8th November 2021

Ref: EP/132.21. Application for Non-Material Amendment Following Conditional Planning Permission, 27a Sea Lane, East Preston, BN16 1NH. (EP.2.21HH).

Front Elevation (west)

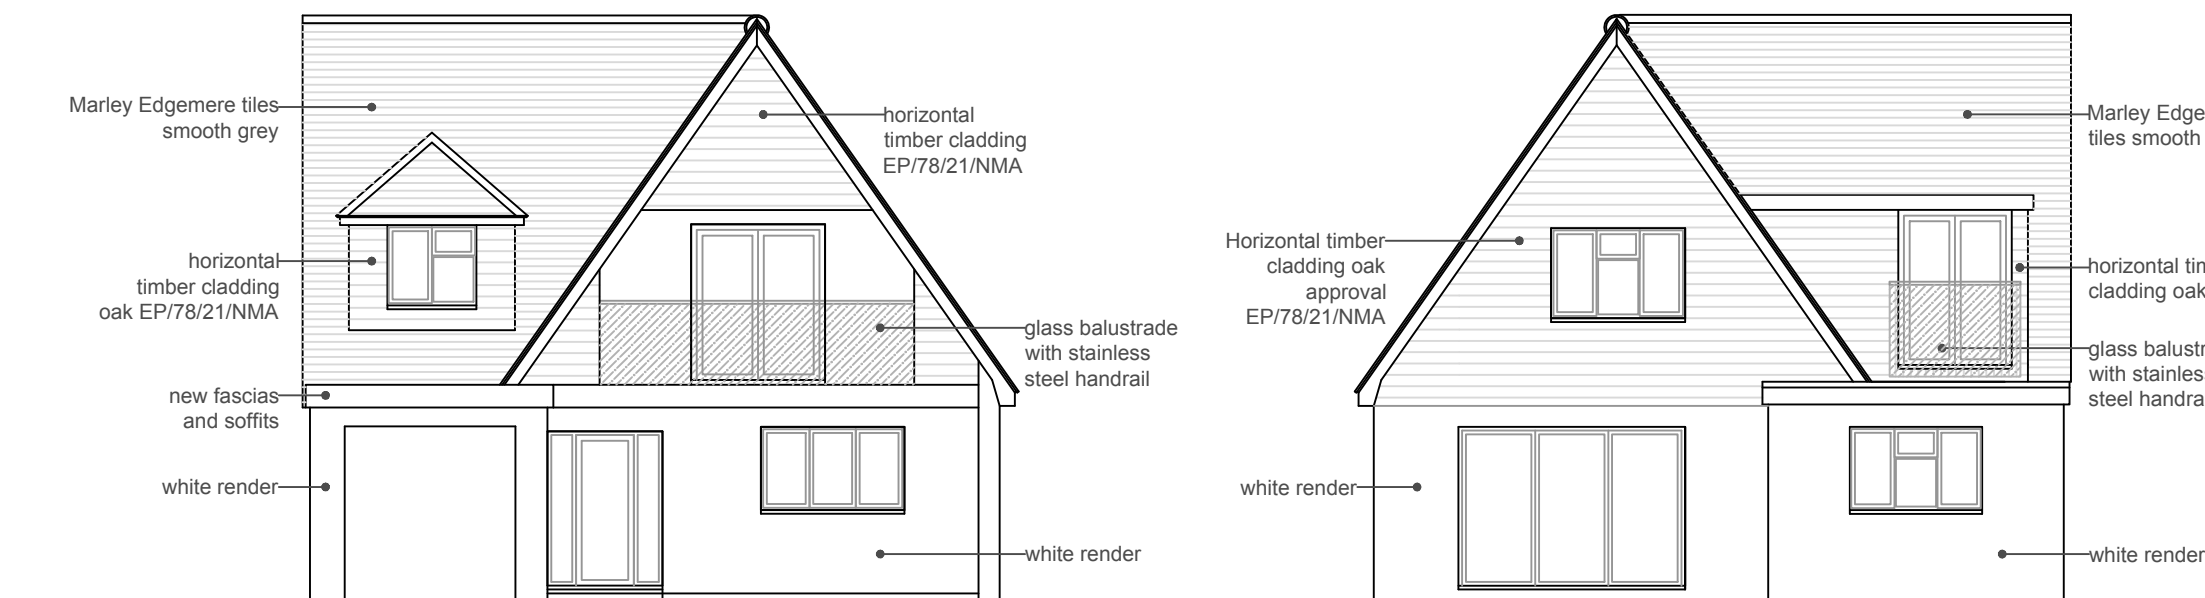
I also wish to bring to your attention the work which is being done at the front of 27A Sea Lane, East Preston. I believe permission was granted for a balcony at the front of the property, again

totally out of keeping with the rest of the road and giving no particular benefit as the outlook would only be to the massively high and solid hedge at the side of Angmering Court and possibly overlooking their garden area as well. Why build a balcony when there is no attractive view to look out on? Is this to be used for surveillance purposes too? One begins to wonder as this "balcony" will also overlook my front garden, and that of No.29 Sea Lane as well, and possibly 23 Sea Lane. Having lost ALL privacy in my back garden when No.23A Sea Lane was erected, without posting of notice of intent, so no opportunity to object, even though the approved plan included a part of my garden without my knowledge, I can readily sympathise with the entire surrounding properties of 27A and the loss of privacy caused by the work being done there!

I attach photographs of the present state of the work being done. This does not look like a balcony, more like an extension of the room behind. There are supporting structures for a roof and sides to the "balcony" as well as a very strong floor platform. On Saturday, 6th November, two "Acro's" were added to support the crossbeam at the front of the structure, presumably to support a heavy roof, confirming my suggestion that this is rather more than a balcony! I also note that there are two doors leading from the room behind, yet the approved plan was, as at the back, for one door and two half windows! Another change without notification to anyone? Another way of getting back to the original plan which was rejected, hoping no one would notice? And again, no ventilation to the room behind unless the doors are open. When open, the doors will catch all the strong winds coming up off the sea, a frequent occurrence here so little opportunity to have the doors open so little ventilation to the existing room. Not a healthy option I feel. Windows could be opened for proper ventilation far more satisfactorily. I find it difficult to believe that this will just be a balcony as originally agreed. Is something else being sneaked in by the back door so that residents around can't object until it is too late?

Rear Elevation (east)

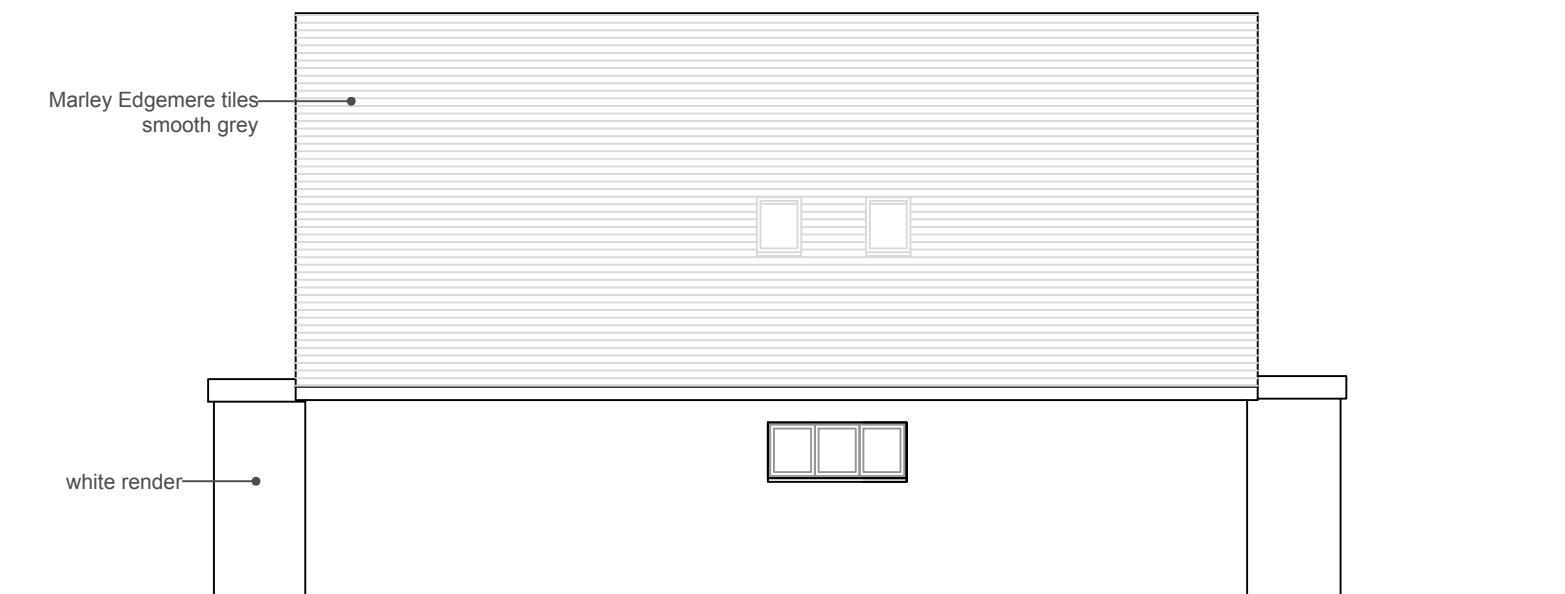
I am writing to protest about the change made to the work being done at 27A Sea Lane, East Preston. I was walking my dog through Two Acres and saw that the work done at the back of 27A Sea Lane had reverted to two full doors instead of the one door and two half windows which had been agreed on the amendment to the original plan. My objection to the original plan, and that of a good few other people, was that all privacy would be lost for the [REDACTED] gentleman now residing in the annexe to 27 Sea Lane, well in his [REDACTED] and deserving of a bit of respect and privacy at his age. Our objections were listened to and the plan changed to one opening door, with half windows either side and a "Juliet" balcony i.e. basically only a safety metal frame a few inches from the door. This could give ventilation to the room without the doors being opened, a healthier option in my opinion than having to open the door in all weathers for fresh air.

I attach a photograph I have taken from Two Acres, showing the two full doors, thus reverting to the original plan apart from the full balcony. Once again, Mrs [REDACTED] father will be fully overlooked in his entire living area, the garden of 27 Sea Lane will be totally overlooked, and there will be serious loss of privacy in the gardens of at least two of the three bungalows at the end of Oakleigh Gardens, as two people can now sit side by side at the double doors and keep a watch over a number of other properties and the users of Two Acres. This is grossly unfair and it seems to me that the original plan is largely being implemented by the side door, as people who objected should, I believe, have been notified of a requested change to the agreed plan, and I certainly was NOT notified.
